A417 Missing Link DCO

Joint Councils comments on National Highways
Deadline 2 submission

Gloucestershire County Council, Cotswold District Council,
Tewkesbury Borough Council

2 February 2022

Standard Road Closure to TMC requirements

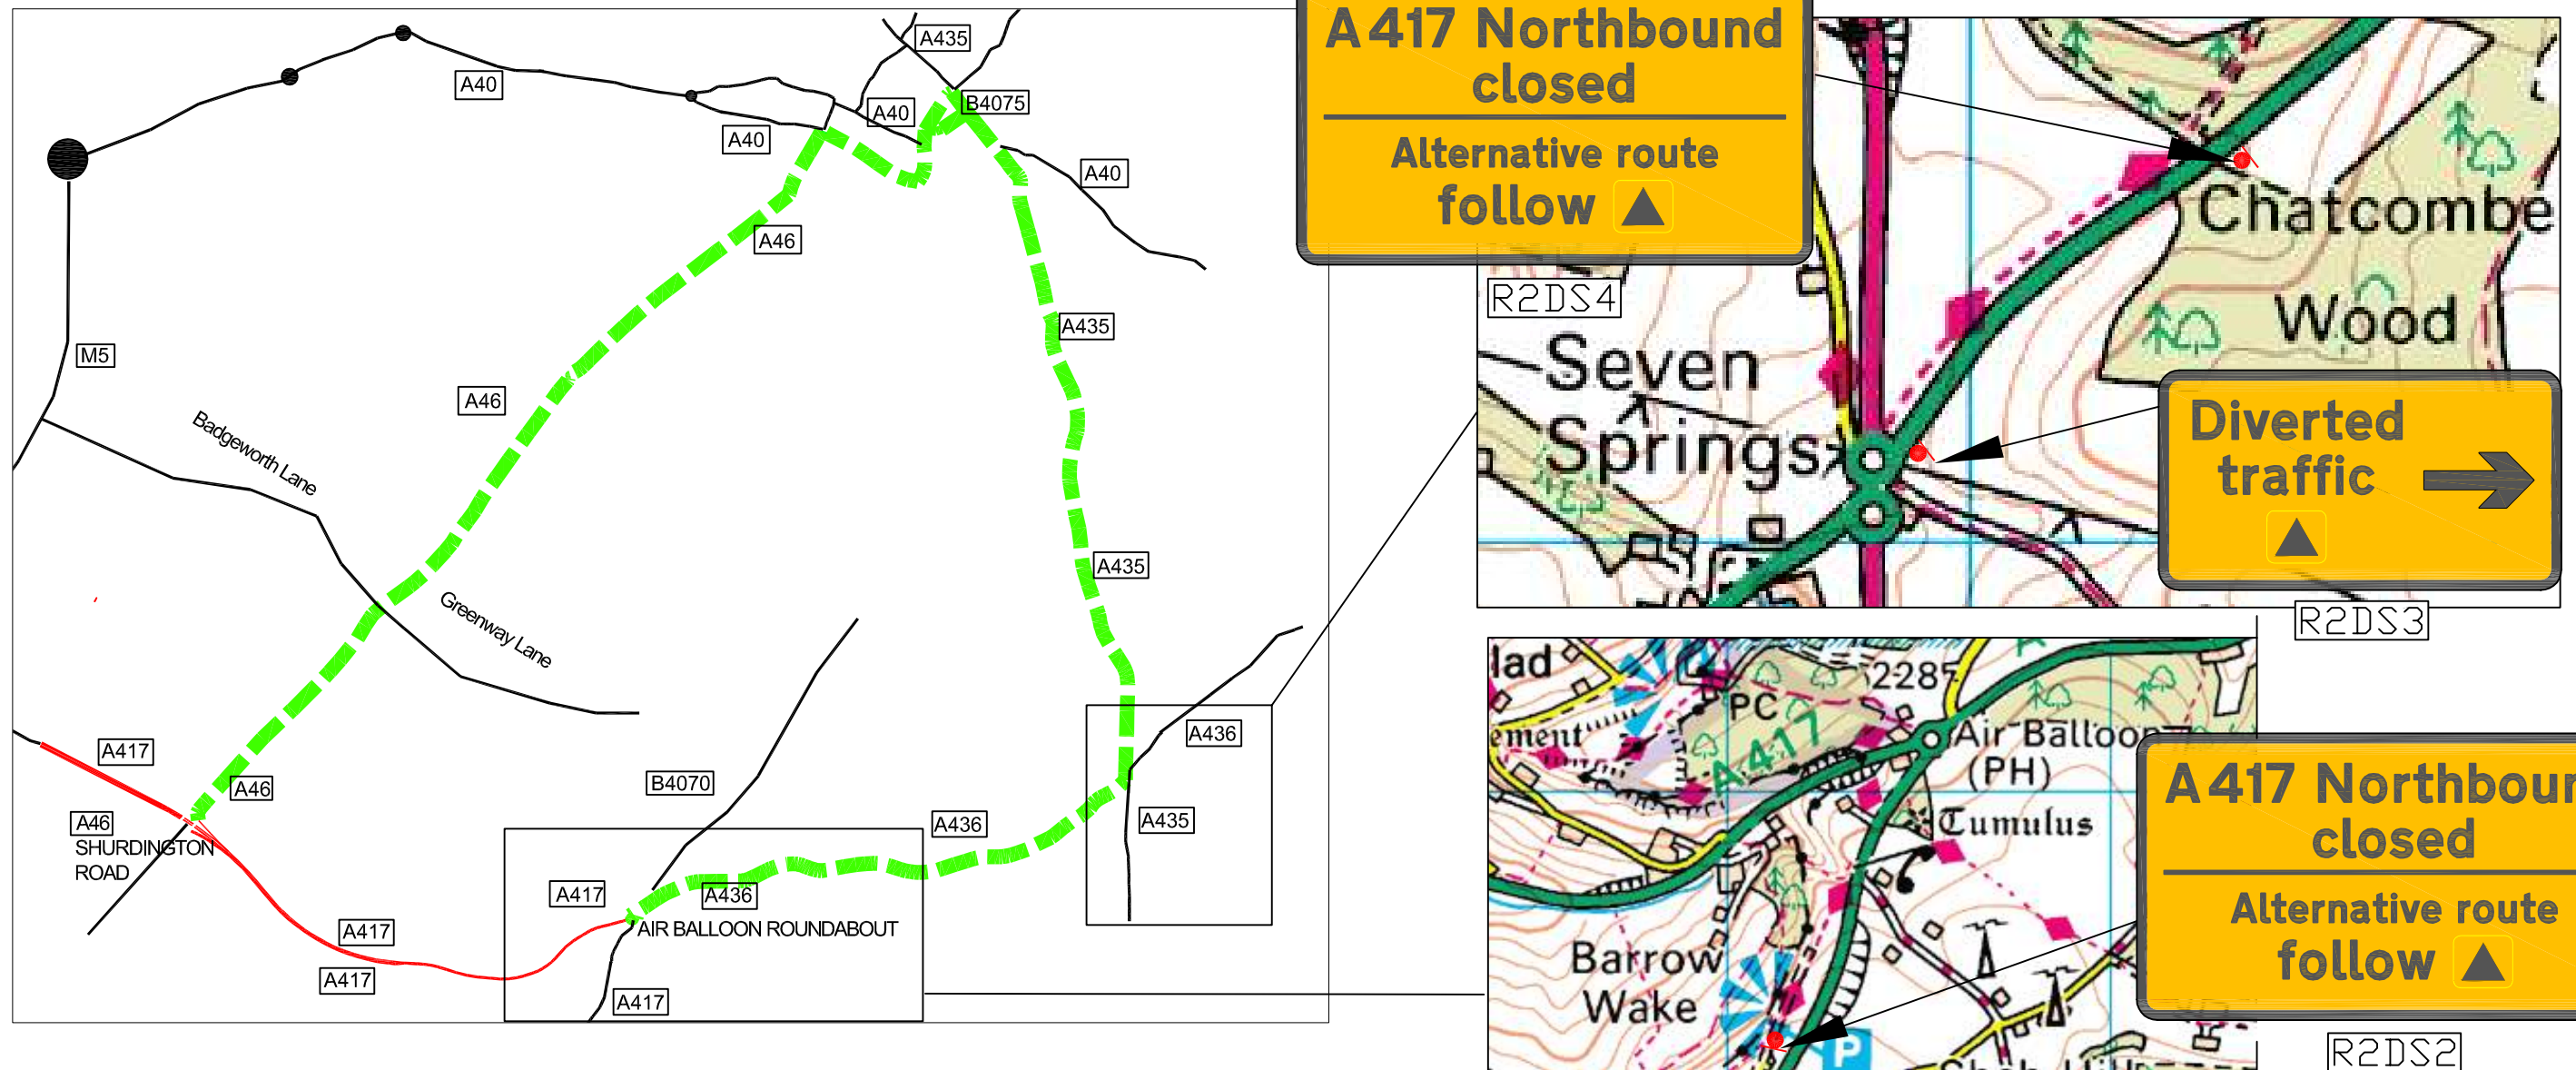
2.1.14	6.4 (Rev 1) Appendix 2.1 EMP Annex B Construction Traffic Management Plan (Tracked)	App F		<p>The two diversion routes set out in the CTMP are aimed primarily at dealing with rerouting strategic traffic movements during closures on the A417. GCC expects that more locally based traffic would divert onto nearby 'shorter' alternative rat-run routes. It is also likely that similar local diversions (traffic reassignment) will occur, although to a lesser extent, when temporary mitigation measures are in place at limited times during the 33 month construction works period e.g. those times when there are 40mph speed limits and restricted lane widths, 40mph speed limits and single lane widths, and 40mph speed limits and contraflow running. For confirmation of the likely impacts, it is therefore recommended that Highways England carry out indicative traffic modelling scenarios for the 2026 year of opening to assess/quantify local network traffic conditions during the scheme construction period when short-term A417 section closures, speed restrictions and lane width reductions are planned to be in operation.</p> <p>The CTMP should set out the details of appropriate mitigation measures to address any identified issues on local roads, for example details of a temporary signage strategy to be installed along the A435 to deter diverted traffic from using High Cross and the lanes through Cowley and Stockwell to access the A417.</p>
